KITTITAS COUNTY

DEPARTMENT OF PUBLIC WORKS

MEMORANDUM

TO: All Staff
FROM: Public Works Plan Review Team
DATE: November 28th at 4pm
SUBJECT: CU-23-00002 The Outpost

**CONCEPTUAL SITE PLAN
MULTIPLE PARCELS**

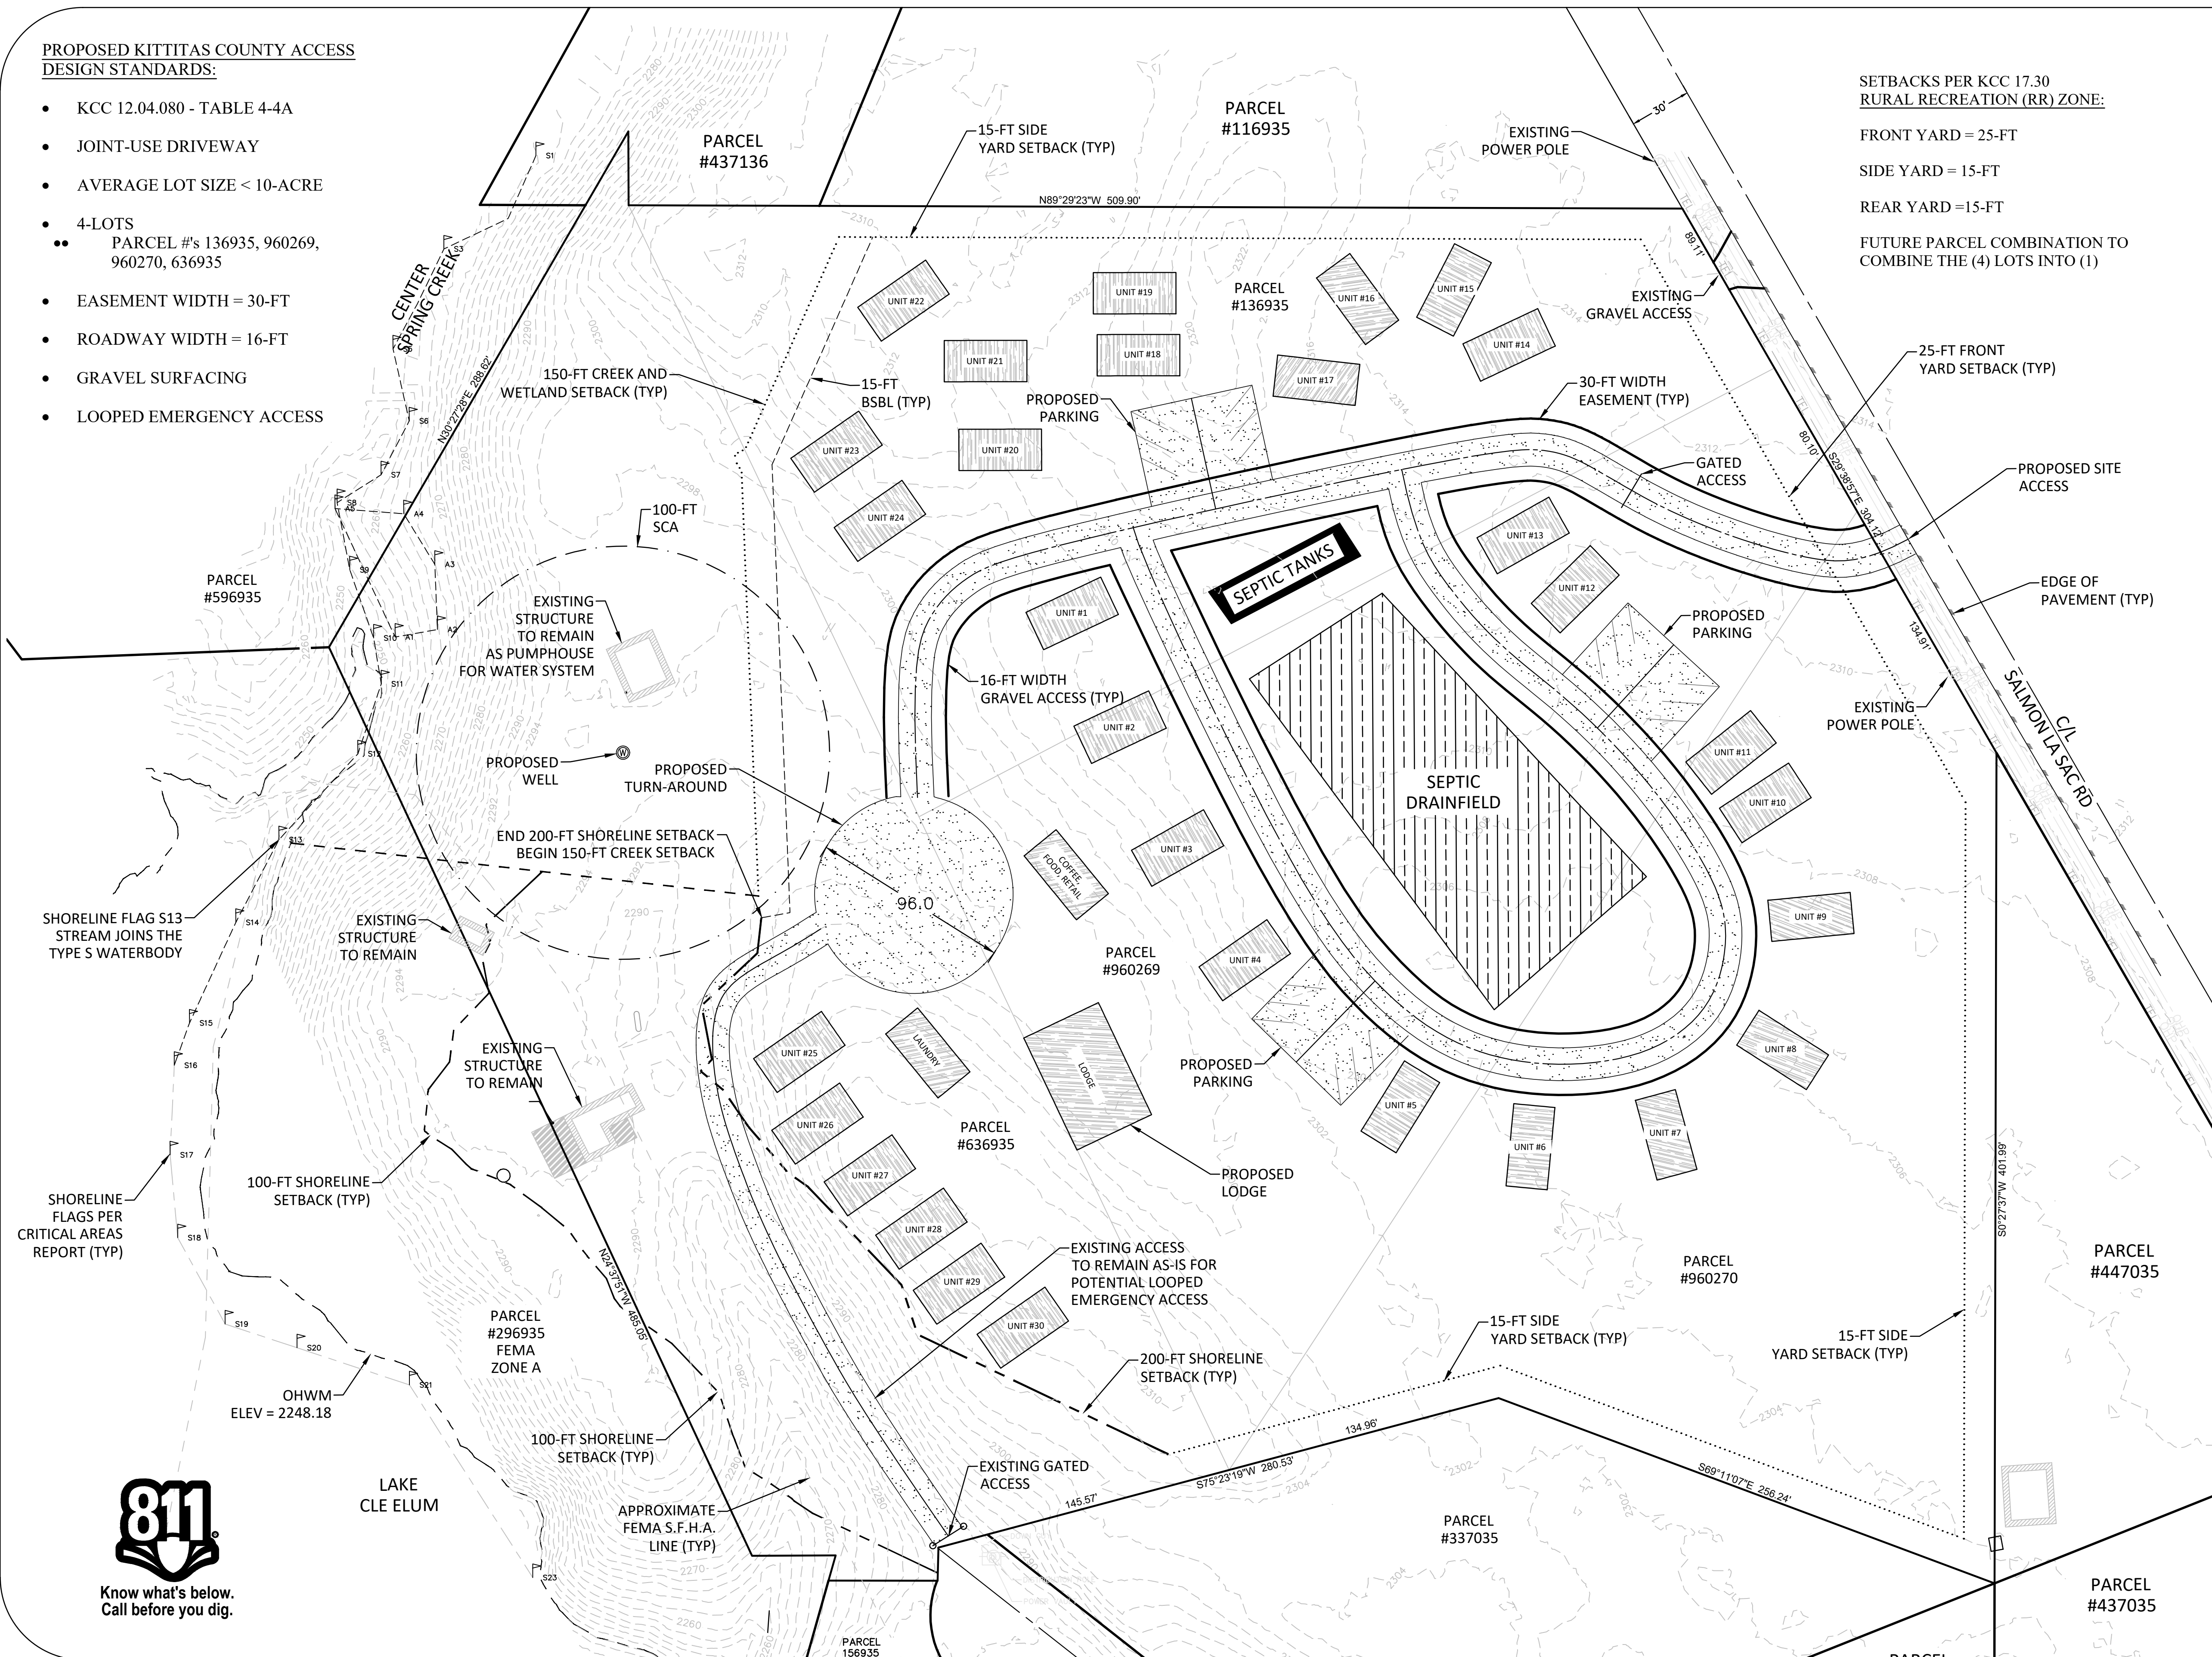
<p>ACCESS</p>	<ol style="list-style-type: none"> 1. An approved access permit for commercial use will be required from the Department of Public Works prior to creating any new driveway access or performing work within the county right-of-way. 2. Maintenance of Driveway approaches shall be the responsibility of the owner whose property they serve. The County will not maintain access. 3. All commercial and industrial accesses shall be designed in accordance with Exhibits 1340-1 and 1340-2 Driveway Design Templates of the WSDOT Design Manual and approved by the County Engineer prior to access permit issuance per KCC 12.05.030. 4. Driveways longer than 150' in length are required to provide a Fire Apparatus Turnaround meeting the requirements of Appendix D of the International Fire Code. 5. Spacing requirements for all access points are shown in Table 5-1. Site distance requirements are shown in Table 5-2 (KCC 12.05.080). 6. In addition to the above-mentioned conditions, all applicable Kittitas County Road Standards apply to this proposal. (JS)

<p>ENGINEERING</p>	<ol style="list-style-type: none"> 1. Except as exempted in Section KCC 14.05.060, no grading or filling upon a site involving more than one hundred (100) cubic yards shall be performed without a grading permit from the County Engineer or Public Works designee (KCC 14.05.050). An application for grading in excess of five hundred (500) cubic yards shall be accompanied by an engineered grading plan (KCC 14.05.080).
<p>SURVEY</p>	<p>Conceptual site plan proved (dated Oct, 2023), does not meet the requirements of WAC 332-130-145, in regards to Vertical Datum used, Legend, Basis of elevations (benchmark), source of contours, accuracy, etcetera. (JT)</p>

TRANSPORTATION CONCURRENCY	A Transportation Concurrency Management Application is required (KH)
FLOOD	<p>A portion of parcel # 636935 is mapped in the FEMA identified special flood hazard area (100-year floodplain). The existing garage, cabin, and proposed lodge are all in the mapped floodplain. All activities within the floodplain must be permitted through the floodplain development permit process and follow the regulations within KCC 14.08.</p> <p>To be reasonably safe from flooding, all proposed development needs to take the federally authorized Cle Elum pool raise into account. Along Cle Elum Reservoir, Kittitas County utilizes a community determined Base Flood Elevation of 2254.2 FT NAVD 88, which reflects the pool raise. Depending on site-specific elevation data, portions of this property may be eligible for removal by FEMA from the special flood hazard area with a LOMA. Please contact the Kittitas County Floodplain Manager at 509-962-7523 for additional information. (SC)</p>
